Upper Dearne Valley Environmental Trust (UDVET)

Response to Application No. 2024/62/91934/E – Proposed Development of 11 Wood Street, Skelmanthorpe, HD8 9BN.

ADDITIONAL OBJECTIONS, COMMENTS AND OBSERVATIONS ON TREE OFFICER'S COMMENTS ON THE CHANGED PLANS POSTED ON THE PUBLIC WEB SITE ON 28 MARCH, 2025

Project: Residential Development 11 Wood Street
 Skelmanthorpe HD8 9BN
 Title: Site Plan
 Scale: 1:200 @ A2
 Date: April 2025 Drwg No: LD/245.E (redrawn)

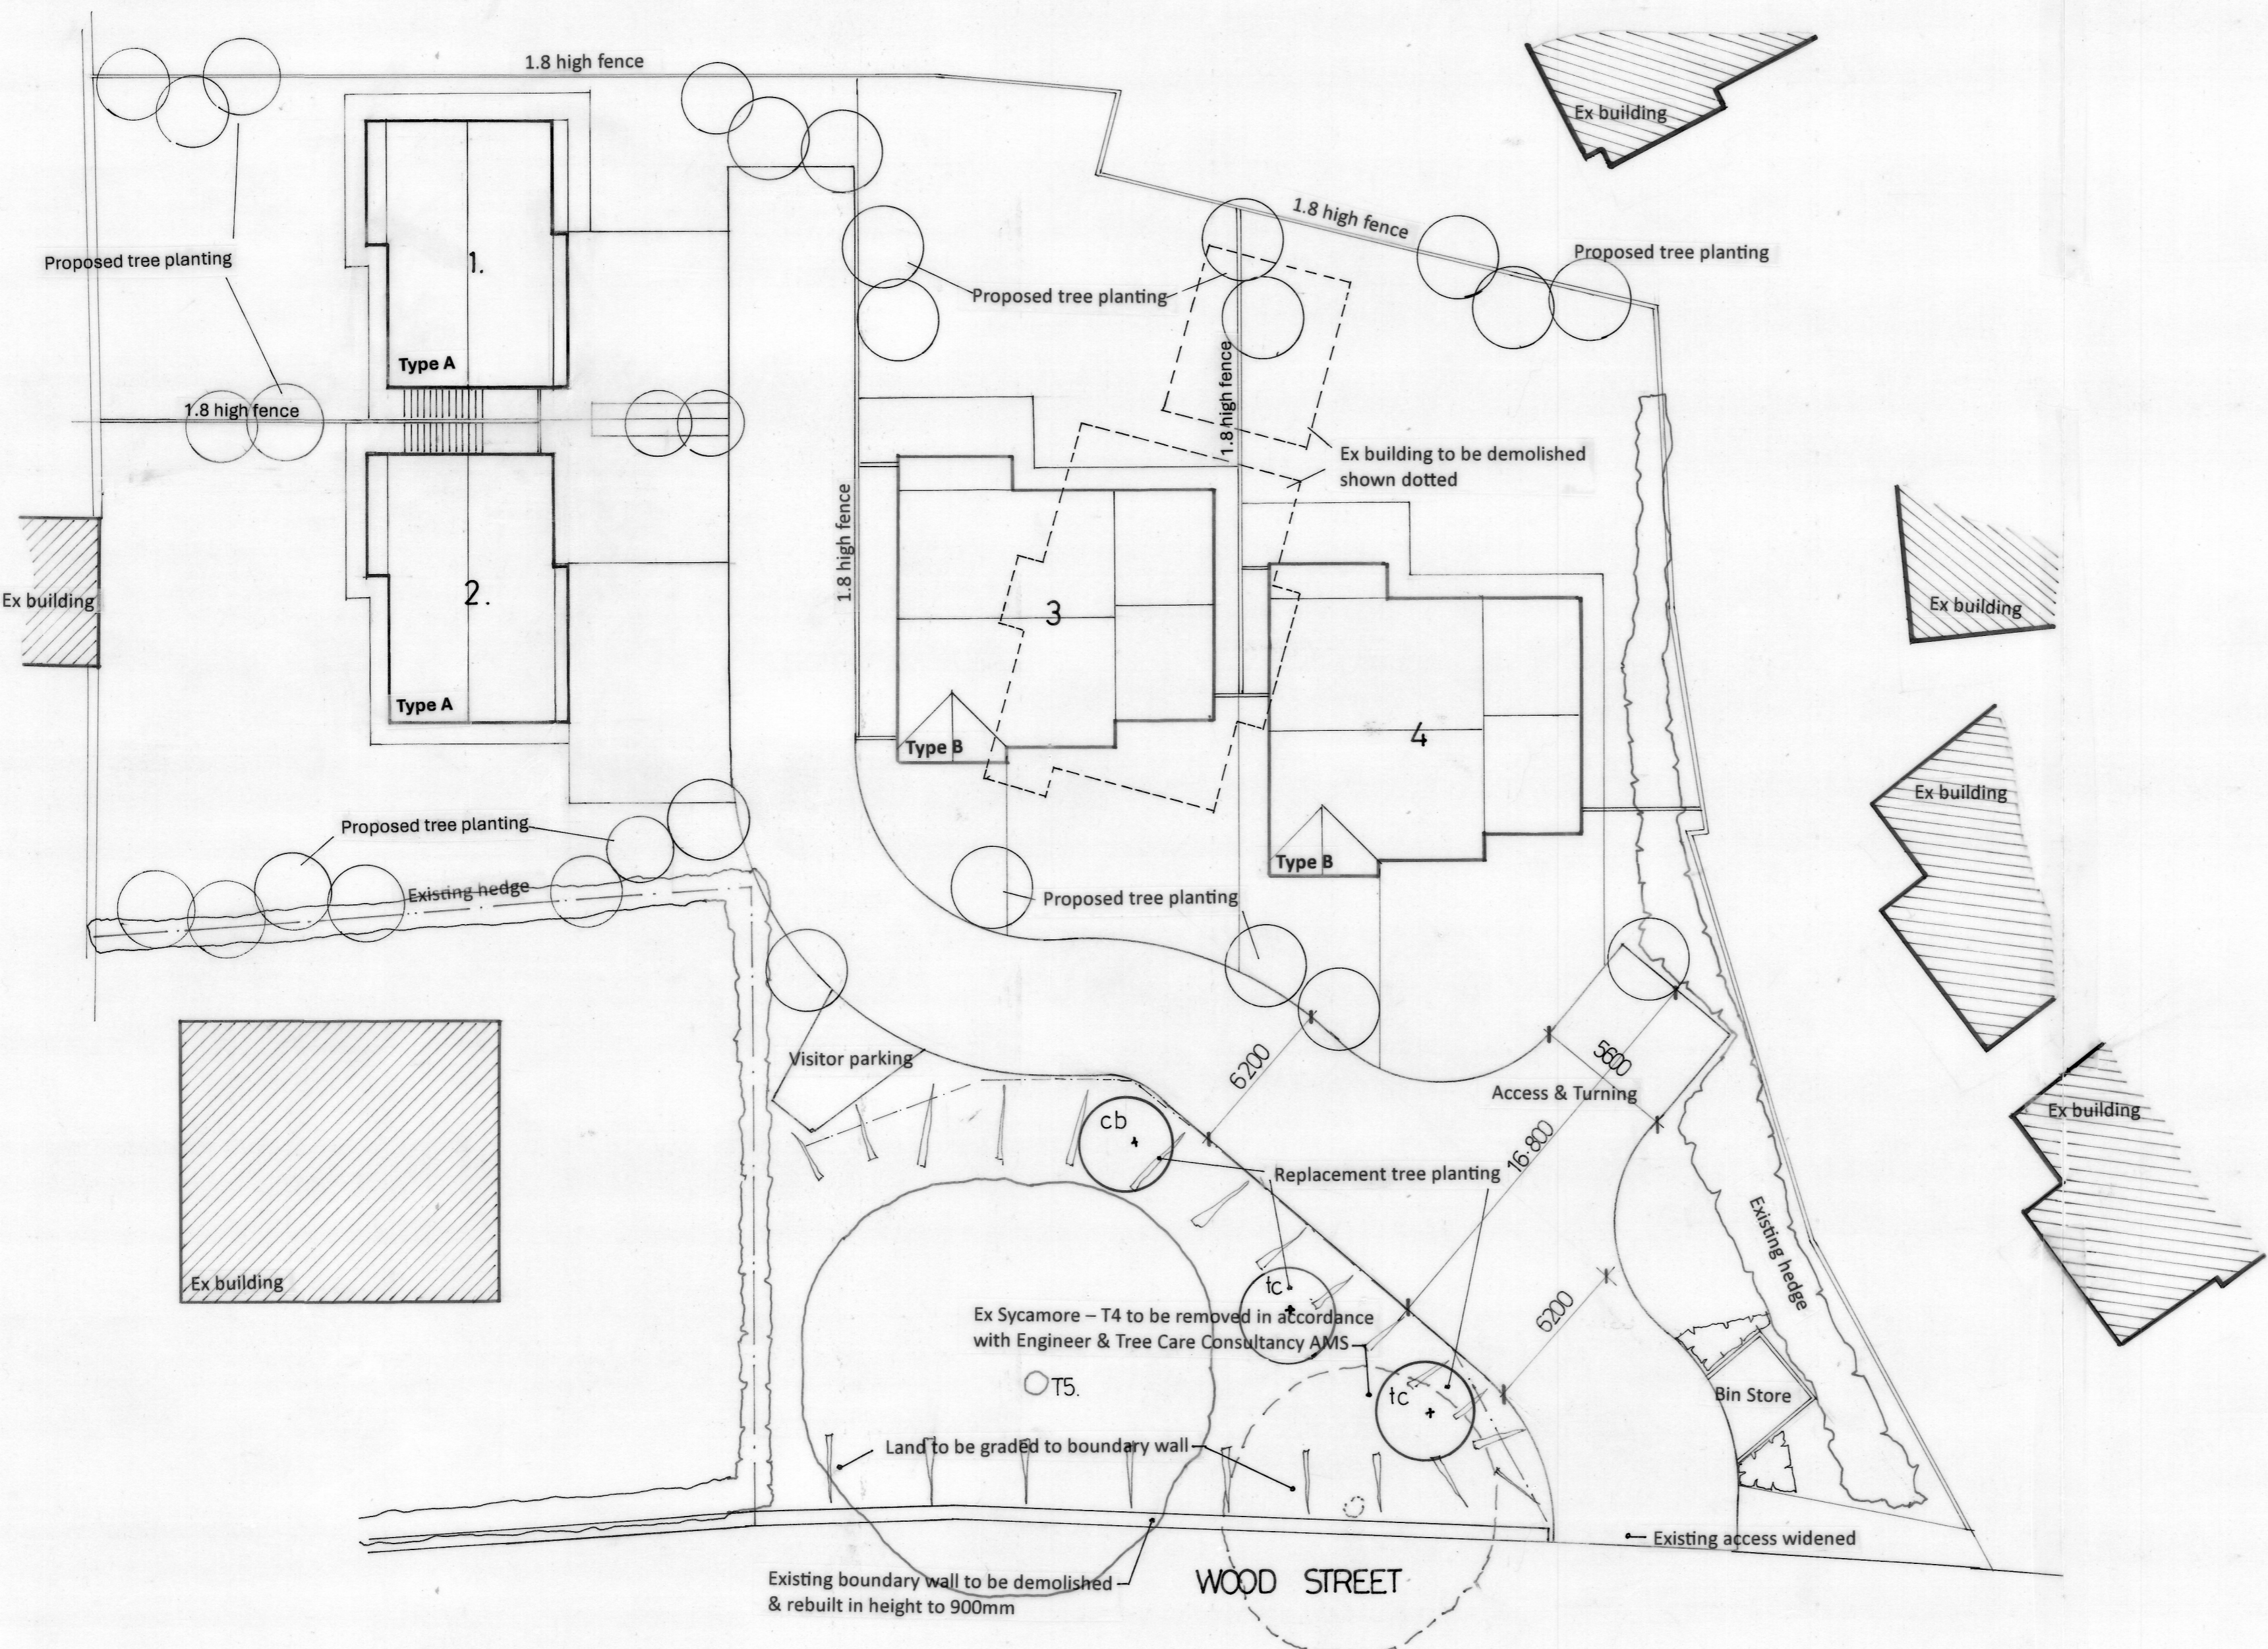
The only bit of this wall that requires rebuilding is a section **below T4 Sycamore**. The rest of the wall does not pose a danger to the public. If that view is being accepted by the Council, then about 90% of the drystone retaining walls in Kirklees Rural would need rebuilding! Given that the LPA is now accepting sandbags as retaining wall material for supporting dwellings (Barnsley Road, Denby Dale) we find the view of this wall as hypocritical.

No alternative construction methodologies have been presented. We have been led to understand that a competent waller could repair this wall in a few days work as happened in 2016 without requiring the removal of T4. **It is our view that the Council should be confidentially seeking the opinion of an experienced waller, completely independently of the applicant or their agents before making any decision on this application which also present many other issues.**

We are thoroughly opposed to the reduction in height of the existing retaining wall to 900mm. Again, we understand from a resident of Wood Street who is a professional Highways Engineer that such a reduction is against regulations given the height and weight of banking it will have to support. We understand that this person has written to Ms. Helliwell on 16 April, 2025 with a number of concerns. At the time of writing, the latter has not been posted on the application web site.

We certainly agree with your statements at (1) and (2). However, these should not be conditions – **they should be a requirement prior to any decision being made about this application.** We believe T4 should be retained PLUS 3x more sycamores to compensate for the destruction to woodland trees already wrecked on this site and loss of habitat.
